7525 Falcon Meadows Blvd., PPR-24-16

Please accept the following comments from El Paso County Public Health (EPCPH) regarding the project referenced above:

PROJECT NAME: **WAT BUDDHANIMIT, TONYKING RUANGSENA**
 PROJECT SITE ADDRESS: **7525 FALCON MEADOW BLVD
 FALCON, CO 80831 (EL PASO)**
 BUILDING SIZE: **36' x 72' x 15' 4" & 24' x 12' x 15' 4" & 24' x 2' x 15' 4" & 16' x 8' x 13' 4"**
 SHEET NAME: **SITE PLAN**

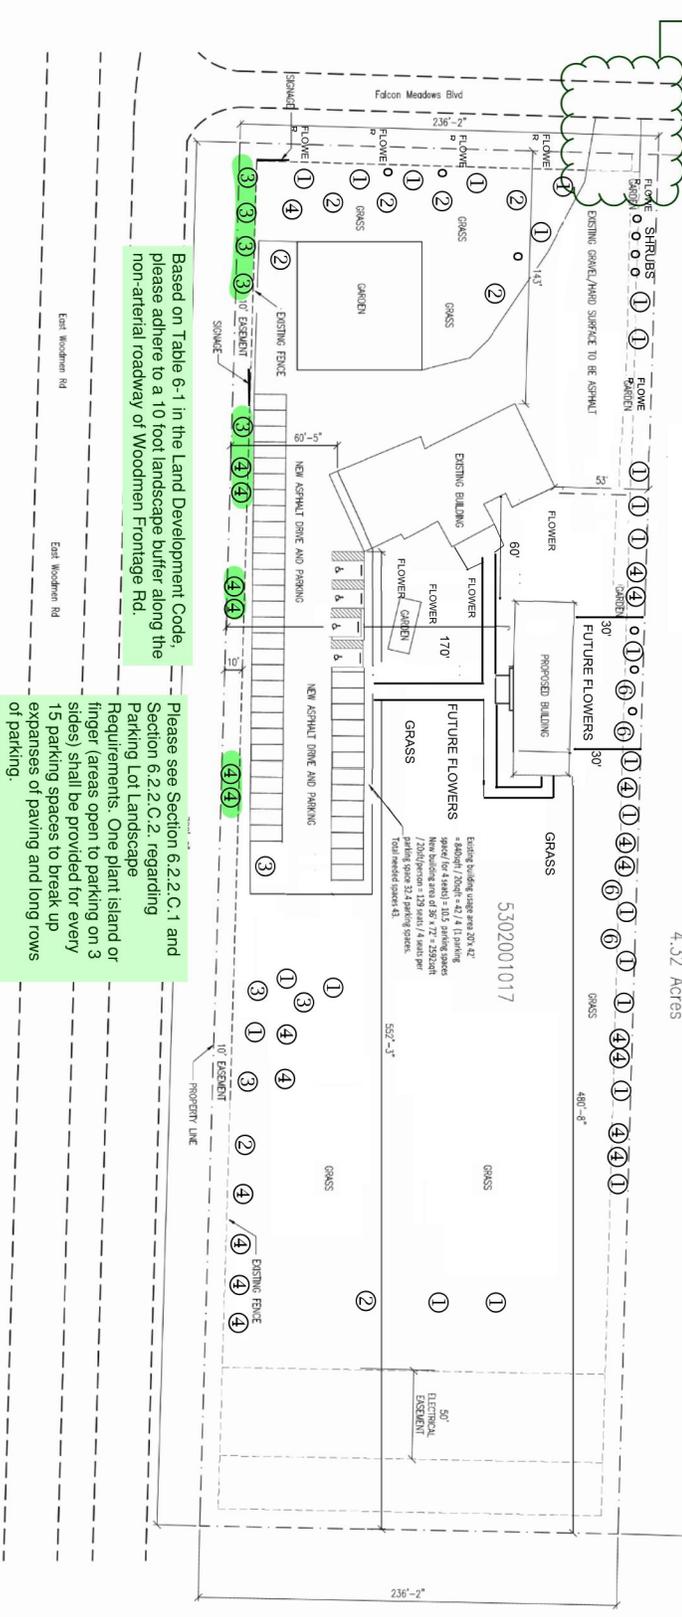
- Please ensure all components of the existing OWTS are located and protected from vehicular traffic, parking, and construction traffic associated with the new meditation hall.
